Your Ref
LU/363/09/
Our Ref
S/AR/2010/363
Date
22/02/2010

Outline application for 1 no. 3 bedroom dwelling
44 North Street Littlehampton BN17 6JH
LU/363/09/

Network Development
Atkins Ltd, for Southern Water

SOUTHERN WATER

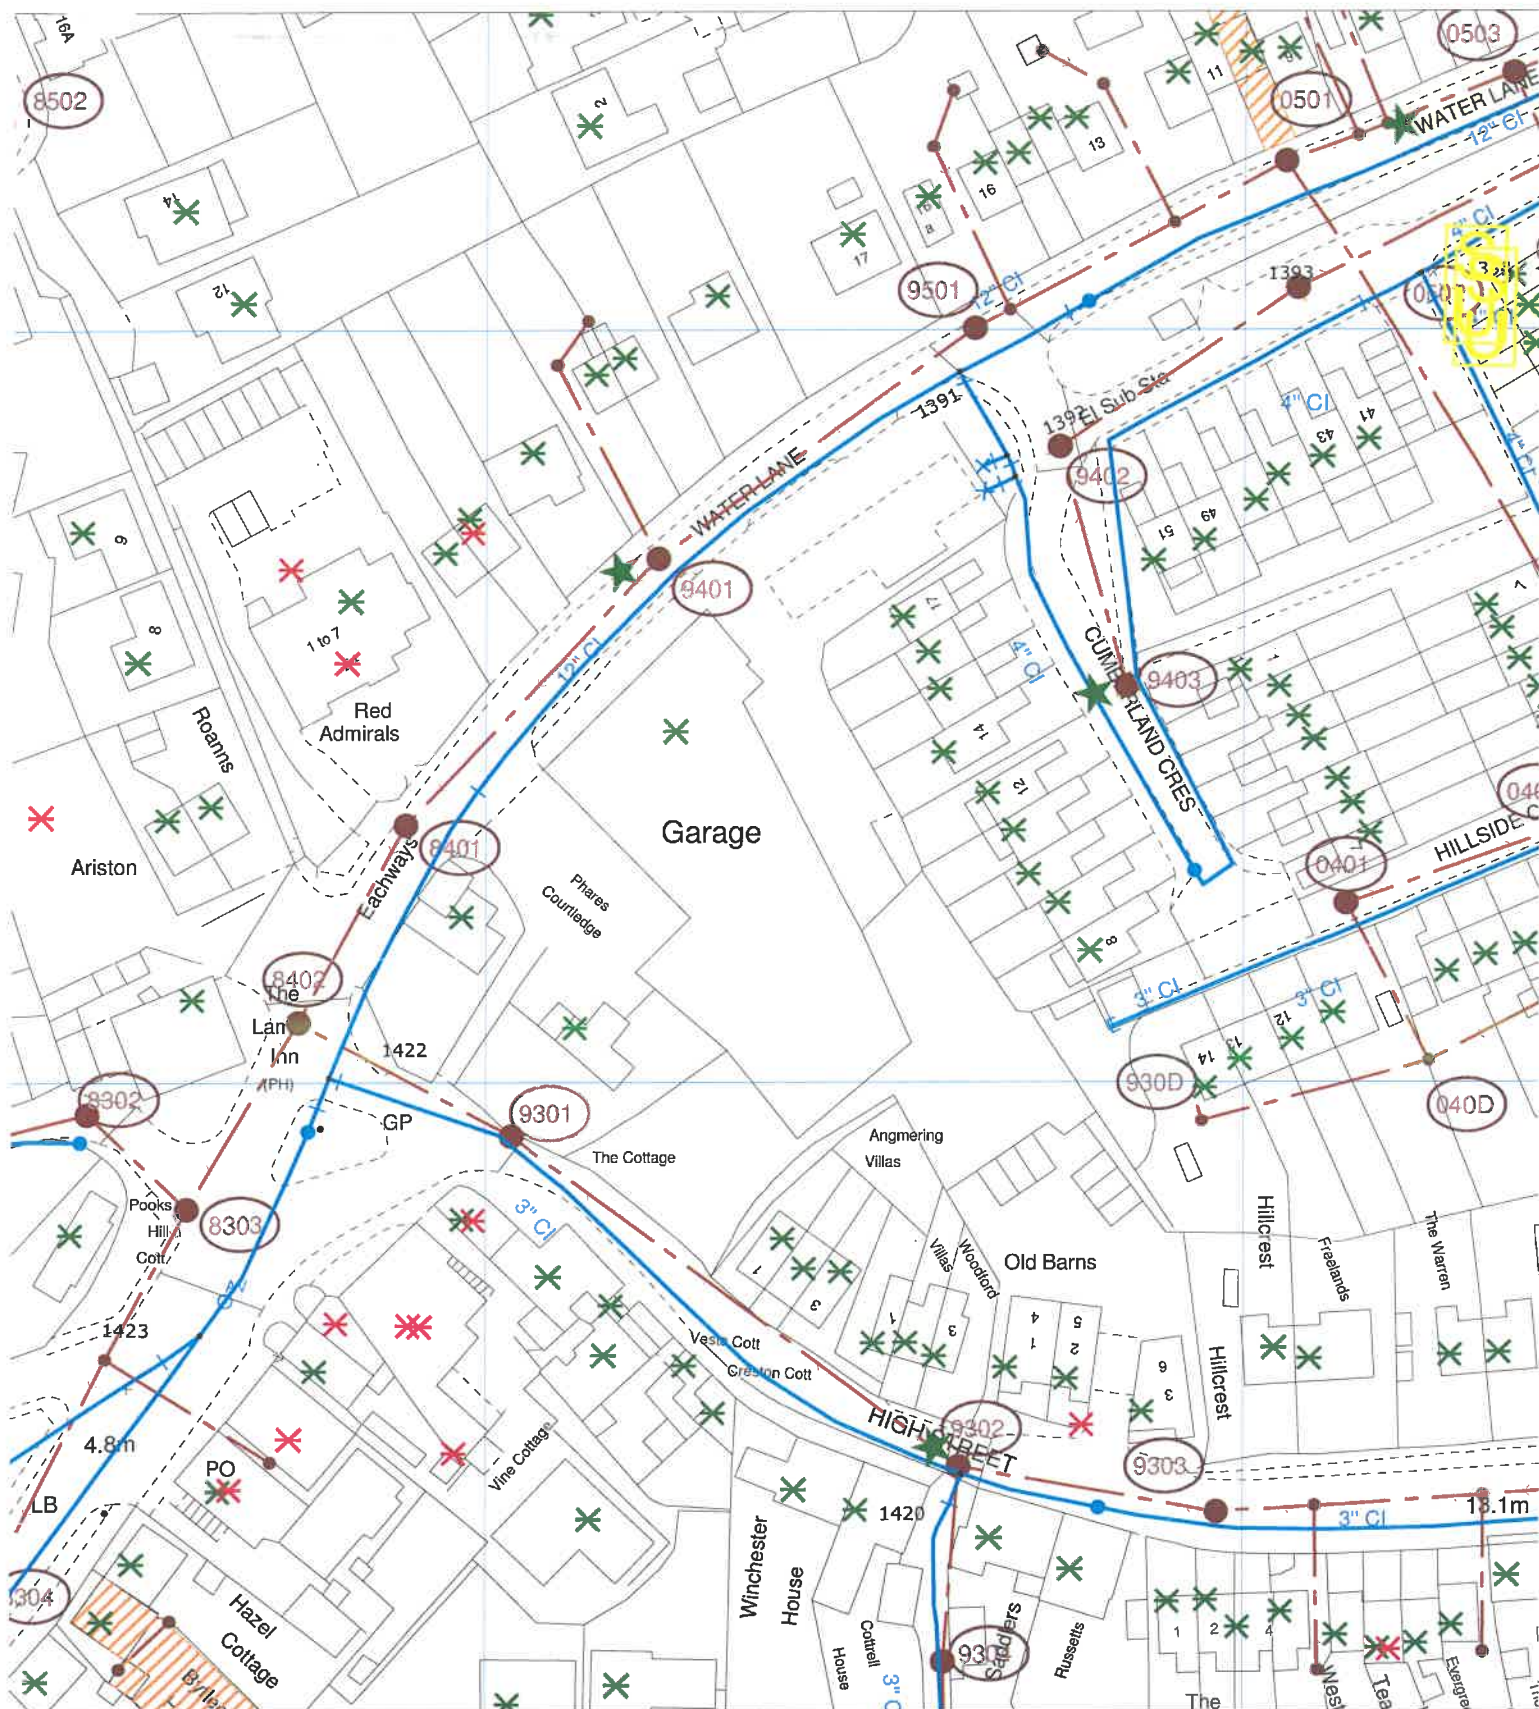
Please find attached a plan of the sewer records showing the approximate position of a public sewer crossing the site. The exact position of the public sewers must be determined on site by the applicant before the layout of the proposed development is finalised.

It might be possible to divert the public sewer, so long as this would result in no unacceptable loss of hydraulic capacity, and the work was carried out at the developer's expense to the satisfaction of Southern Water under the relevant statutory provisions.

1. The 225 mm diameter sewer requires a clearance of 3 metres either side of the sewer to protect it from construction works and allow for future access for maintenance.
2. No development or new tree planting should be located within 3 metres either side of the centreline of the public sewer
3. No new soakaways should be located within 5m of a public sewer.
4. All other existing infrastructure should be protected during the course of construction works.

Alternatively, the applicant may wish to amend the site layout, or combine a diversion with amendment of the site layout. If the applicant would prefer to advance these options, items (1) – (4) above also apply.

In order to protect drainage apparatus, Southern Water requests that if consent is granted, a condition is attached to the planning permission. For example "The developer must advise the local authority (in consultation with Southern Water) of the measures which will be undertaken to divert the public sewers, prior to the commencement of the development."
